Our ref: AE/2018/122655/01-L01
Your ref: *
Date: 28 April 2018

APPLICATION BY PORT OF TILBURY LONDON LIMITED FOR AN ORDER GRANTING DEVELOPMENT CONSENT FOR A PROPOSED PORT TERMINAL AT THE FORMER TILBURY POWER STATION (TILBURY 2) – WRITTEN REPRESENTATIONS FOR DEADLINE 3 - FORT ROAD, TILBURY, ESSEX, RM18 7NR

Thank you for the opportunity to comment further on the application for a Development Consent Order for the proposed Tilbury 2 development. Our response includes comments on documents submitted by the applicant at deadline 2. In particular we have reviewed the level 3 Flood Risk Assessment addendum produced by AECOM, dated March 2018 and the Ecological Mitigation and Compensation Plan reference PoTLL/T2/EX/59. As requested by the Examining Authority our representation also refers to the responses we gave to questions at the Issue Specific Hearings held in relation to Tilbury 2 on 18 and 19 April 2018.

Drawing Title **CULVERT LOCATION PLAN**

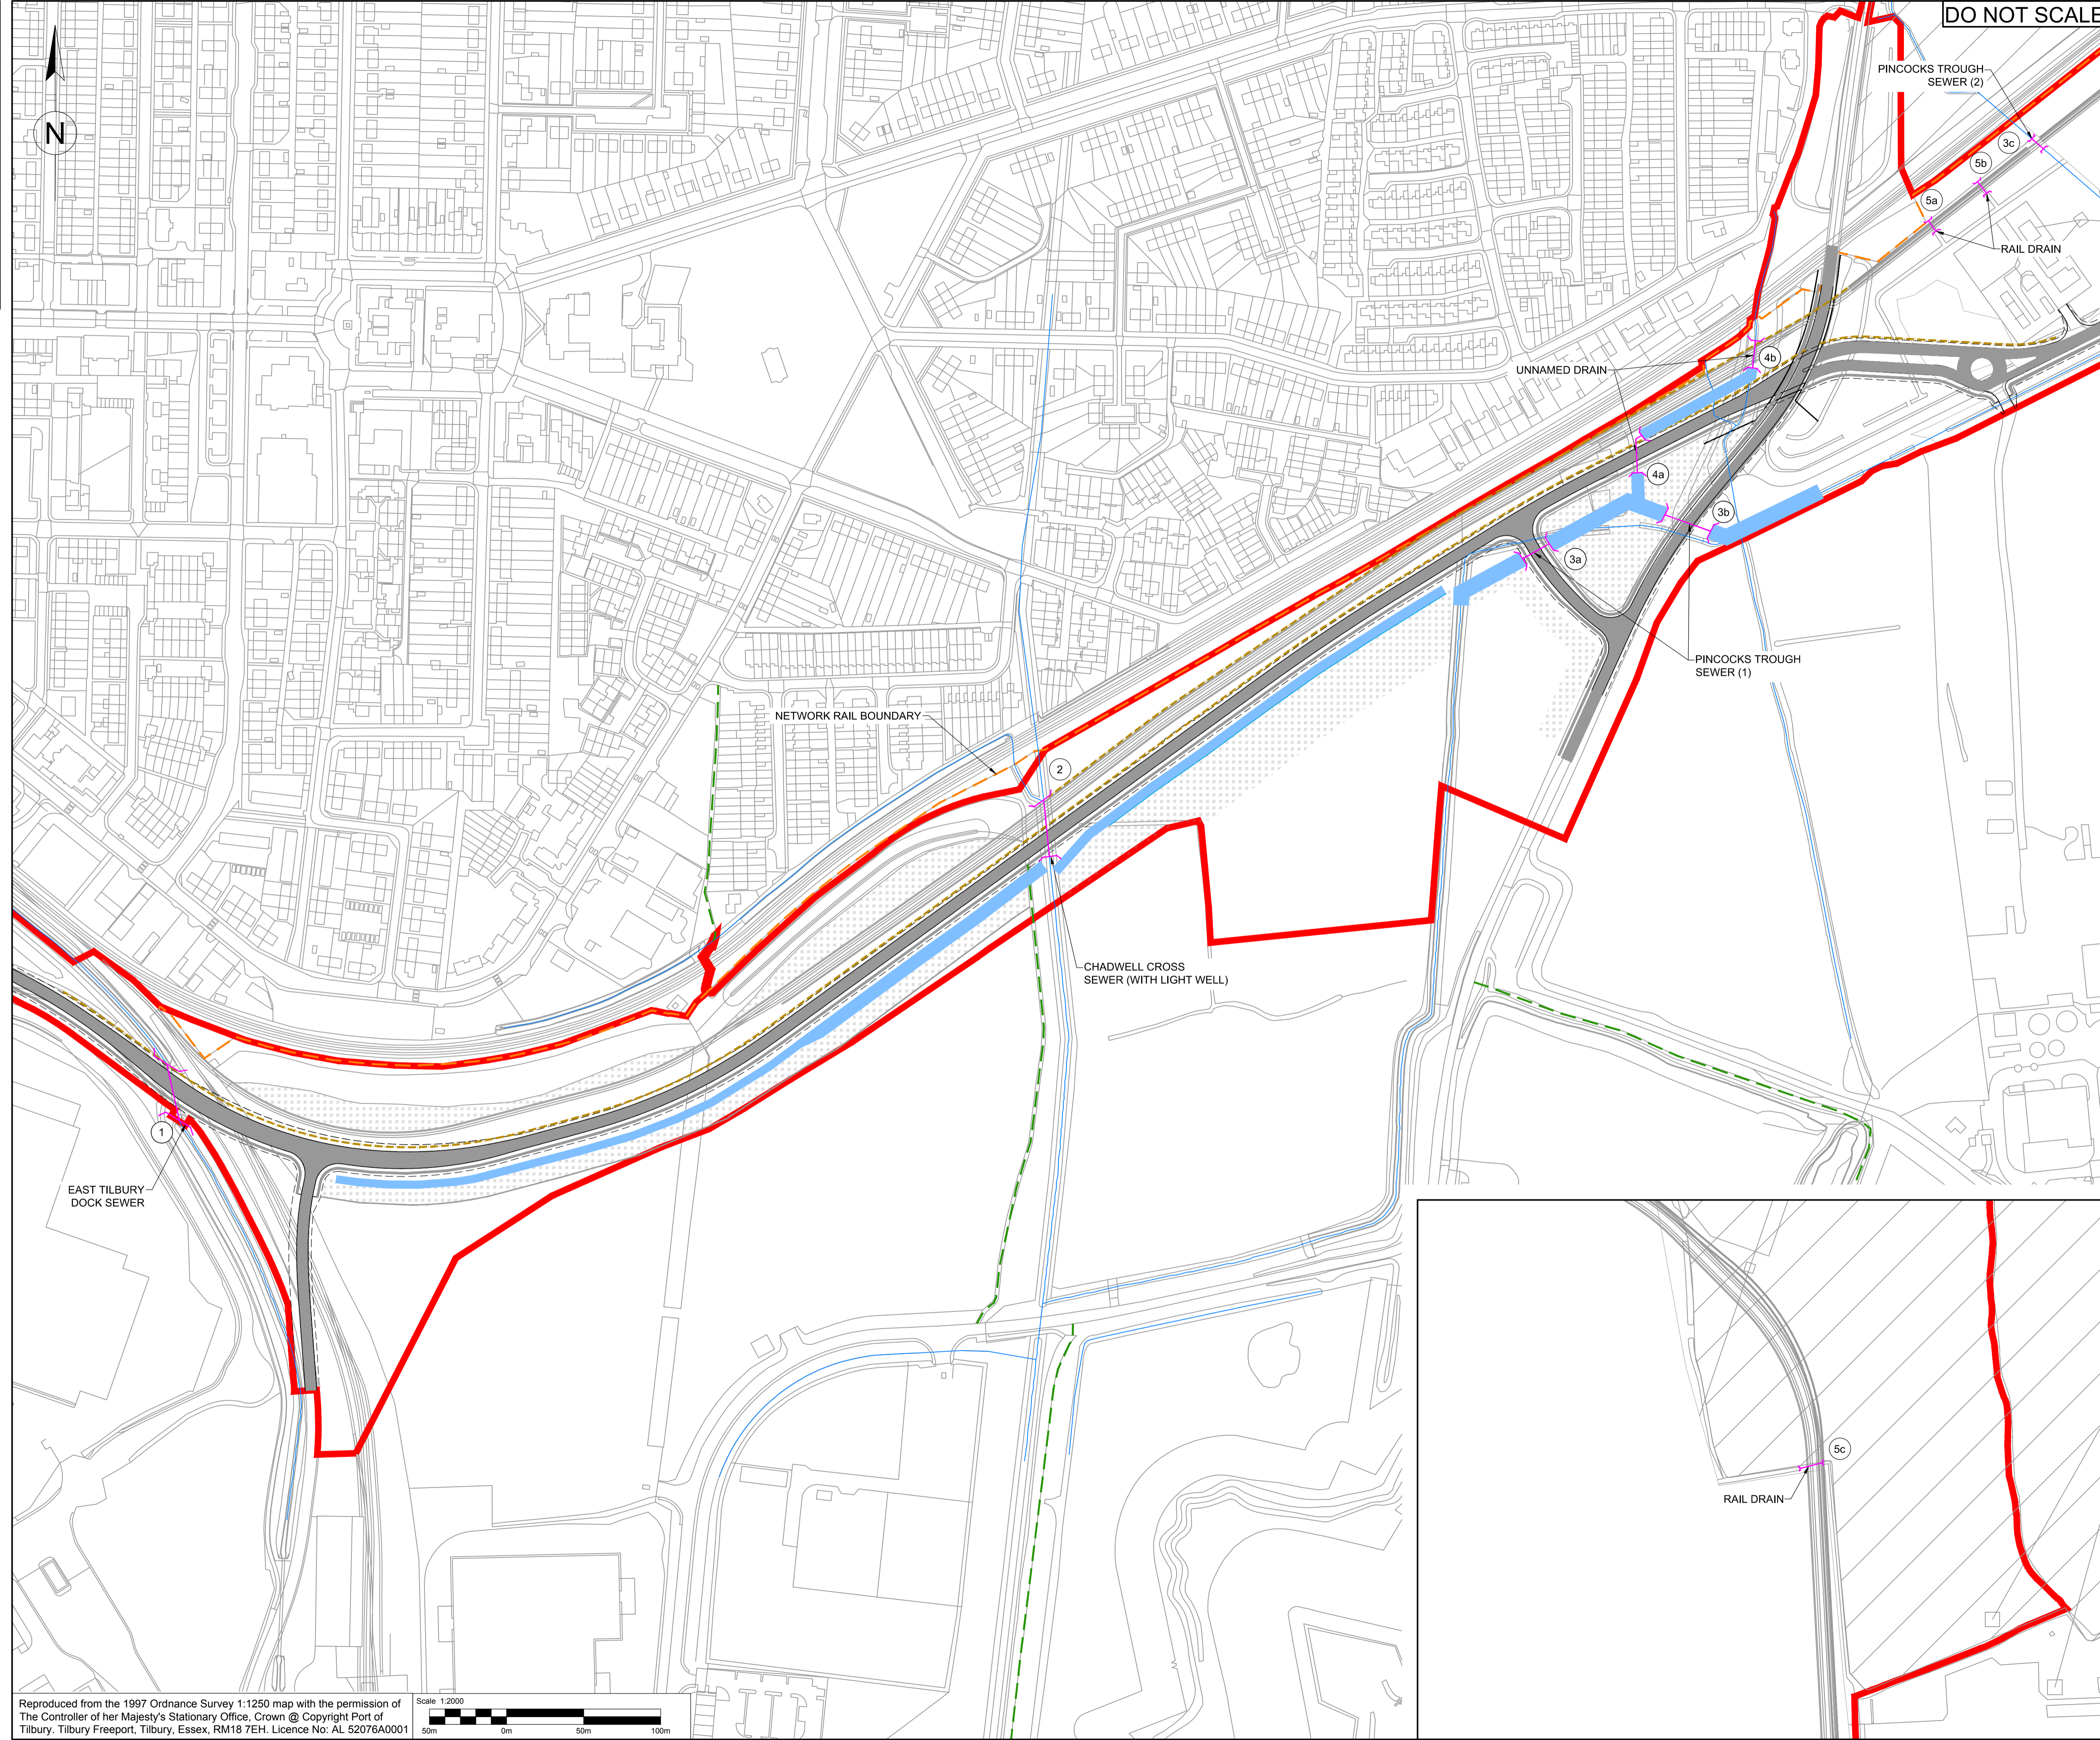
1.8 Cross-sections and long-sections of the proposed culverts have been provided. However details of the existing culverts have not been received. We are aware that the cross-sections of the watercourse shown on the drawings are not always in the same location as the proposed culvert; the correct river cross-sections should be shown on the drawing of the culvert.

1.9 The proposed culverts are not the largest culvert that can be accommodated within the watercourse, they are significantly smaller than the width and depth of the existing watercourse in many locations.

1.10 As previously stated, the proposed culvert should maintain the capacity of the watercourse in terms of the width and depth, and existing sub-standard culverts should not be used to justify a new or replacement insufficiently-sized culvert. If this is not feasible for some reason then robust justification should be provided and detailed mapping of where exceedence flows would go should be provided. Ideally the culverts should be modelled to show they do not increase offsite flood risk. Alternatively the culverts could be designed to contain the design flows, if these are less than the capacity of the watercourse. CIRIA document C689 can be used for best practice in culvert design.

1.11 Culvert 5B is proposed to be three culverts. We look to avoid multiple culverts

wherever possible as the crosswalls can lead to an increased risk of blockage. We would wish to receive further information before we could agree the detailed design of the culverts. We are however satisfied that the detailed design could be secured through the protective provisions, even though we are not confident that the culverts are designed to prevent an increase in flood risk. (Issue Specific Hearing, question 19.5).
